SUBJECT: Engineering Review Comment
Mountain View Electric Association Inc. (MVEA)

Project Name: Mayberry Filing 2A – Vacation Replat and Rezone

Project Numbers: VR2323 and CS234

Description: Proposed development of 3 commercial lots and 1 tract with a rezone to commercial located south of State Highway 94 and west of Log Rd. in Township 14S, Range 63W, Section 14.

VACATIONS OF PREVIOUSLY PLATTED LOTS, ROWs AND EASEMENTS IN MAYBERRY, COLORADO SPRINGS FILING NO. 2

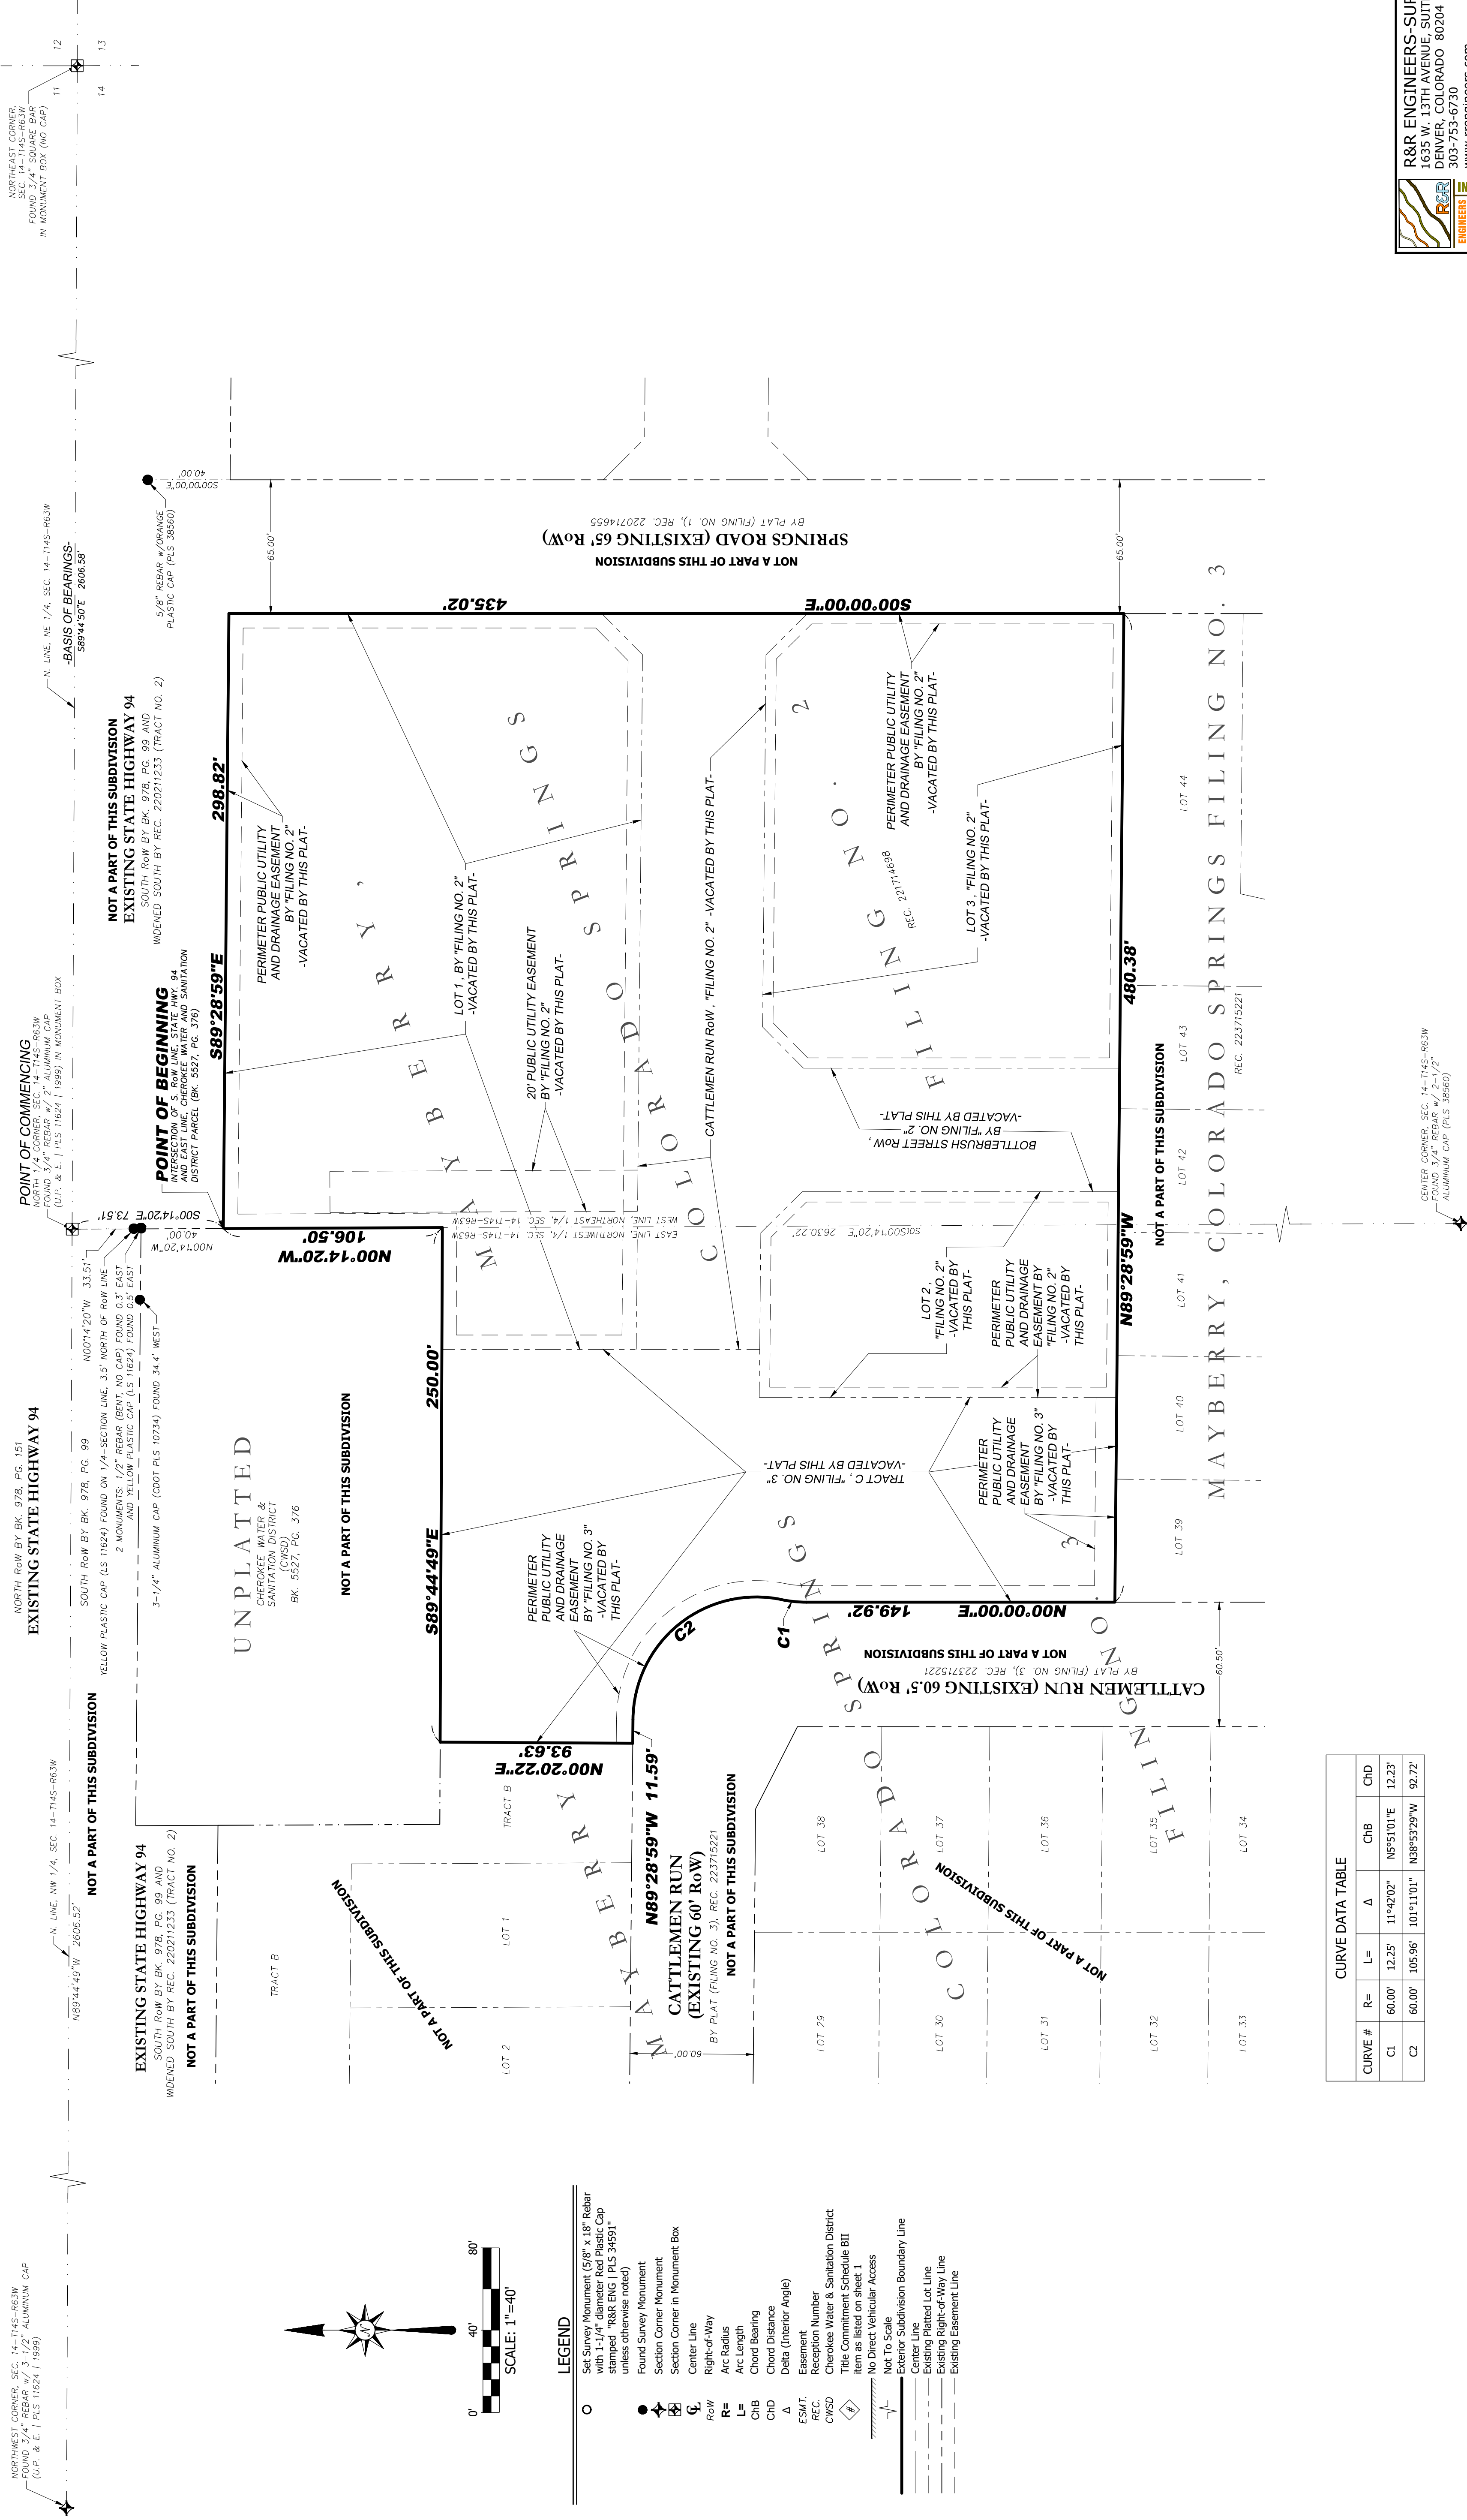
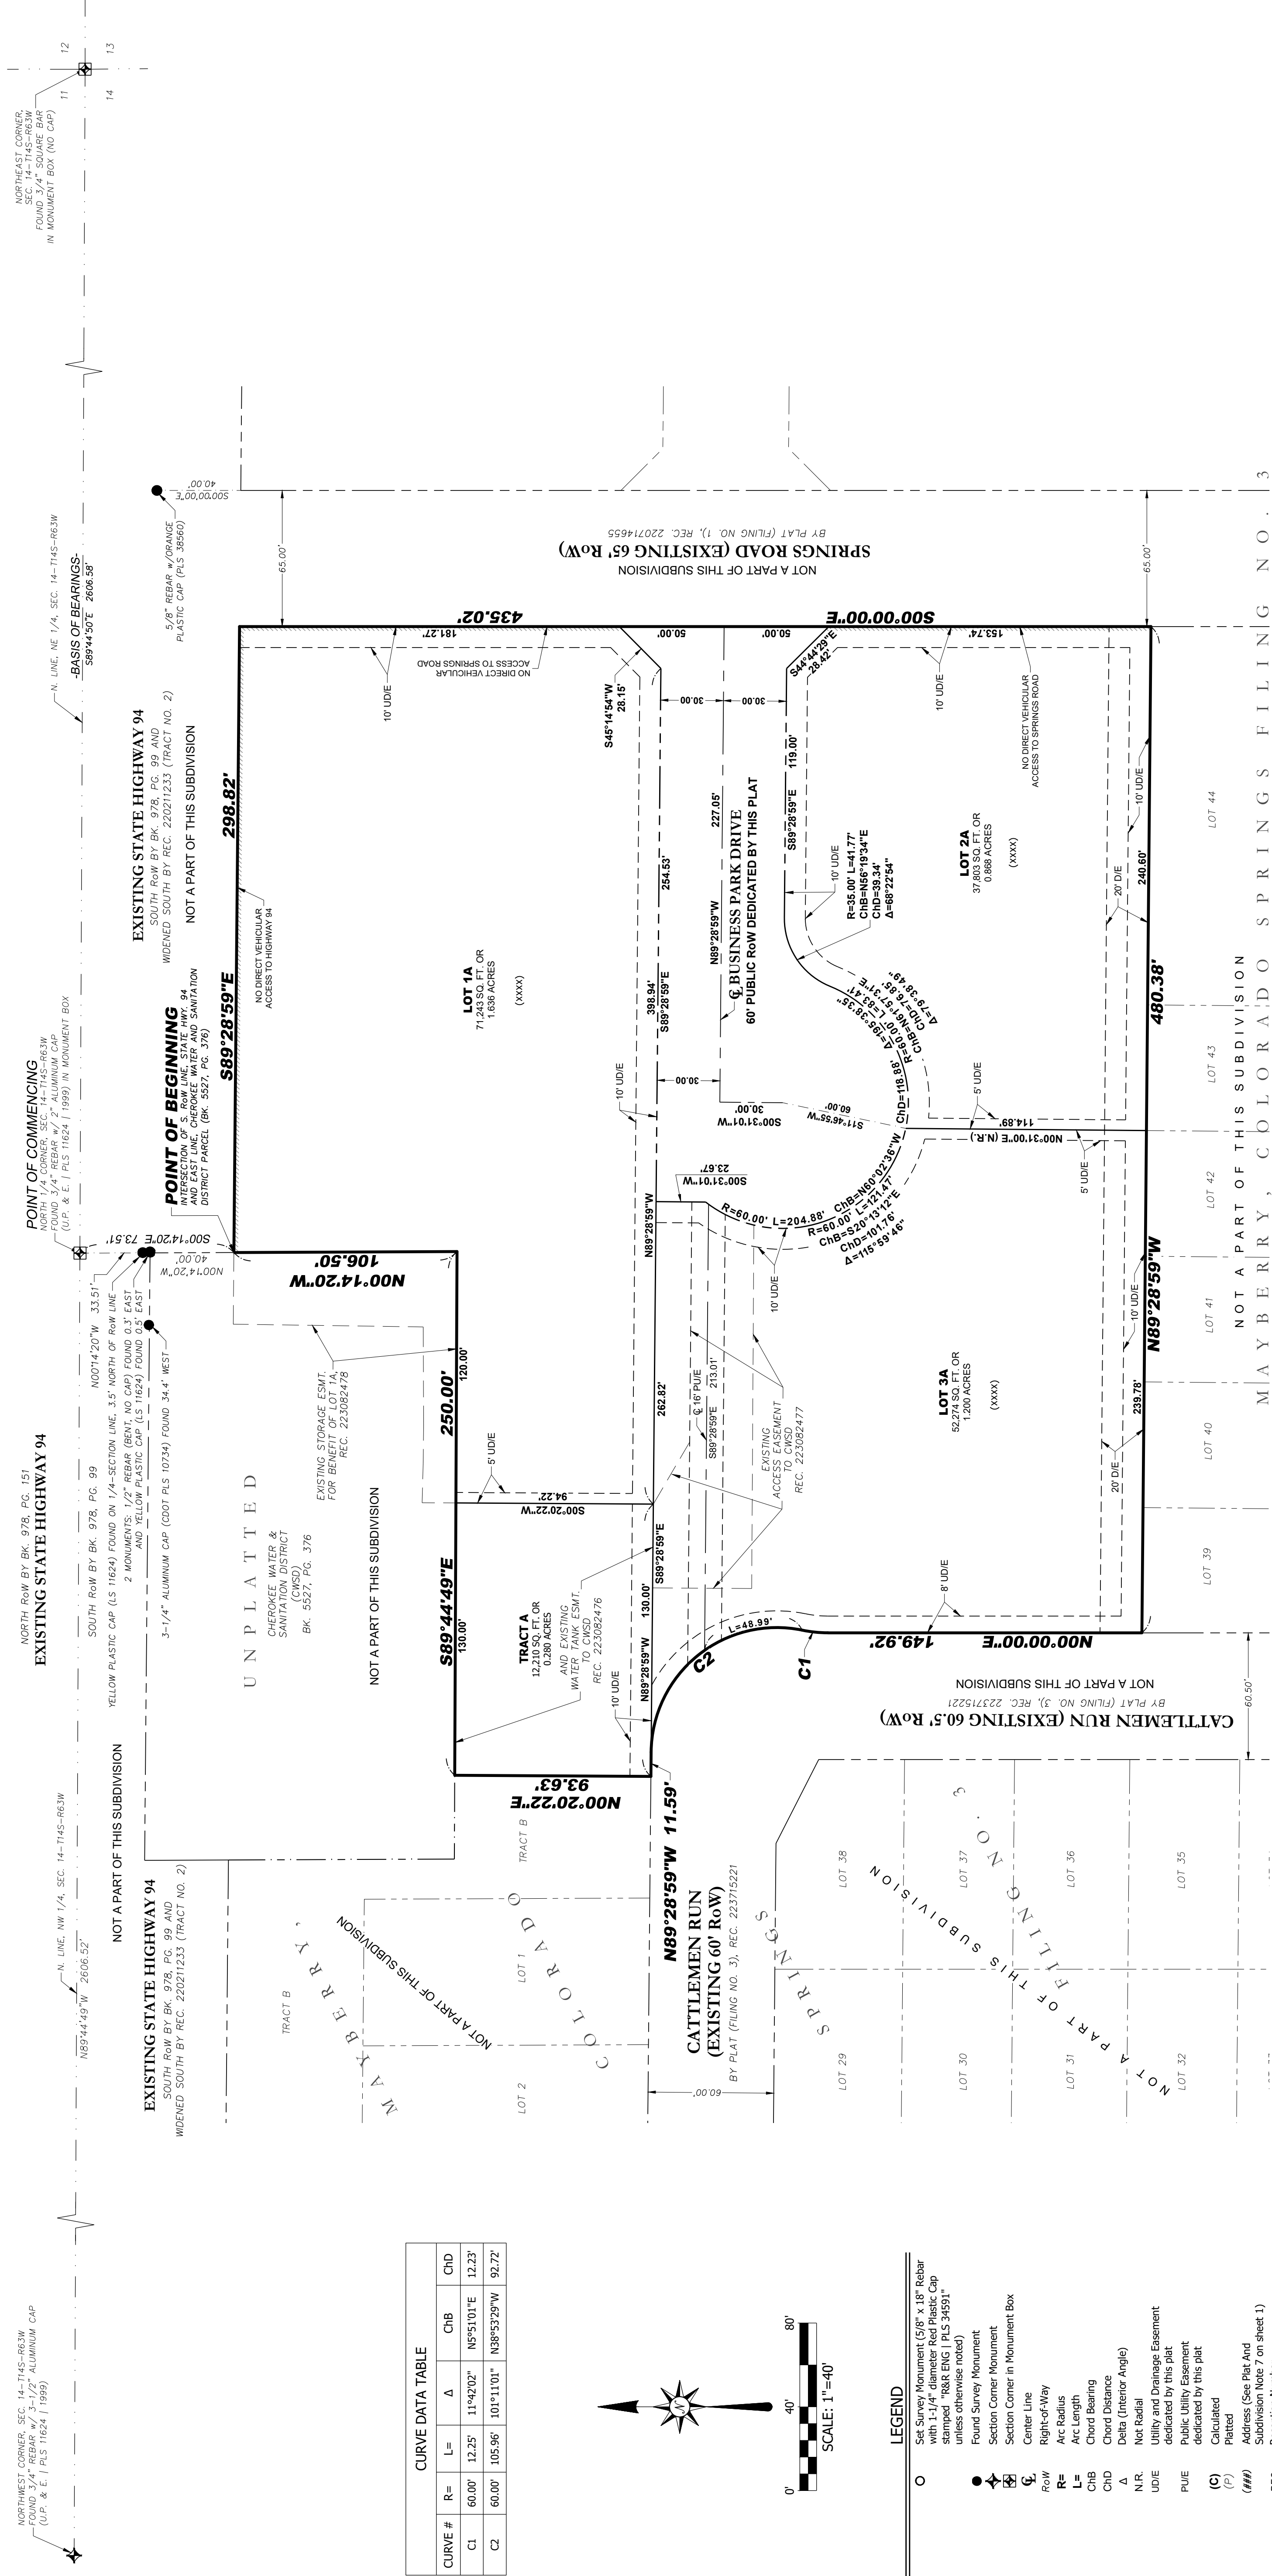
MVEA requests a twenty (20) foot utility easement on the north end of Lot 1A and a ten (10) foot boundary easement on Tract 1. MVEA will work with the developer on the design of the electric service and to acquire any additional easements. MVEA also requests the platting of MVEA's existing facilities with easements on the plat.
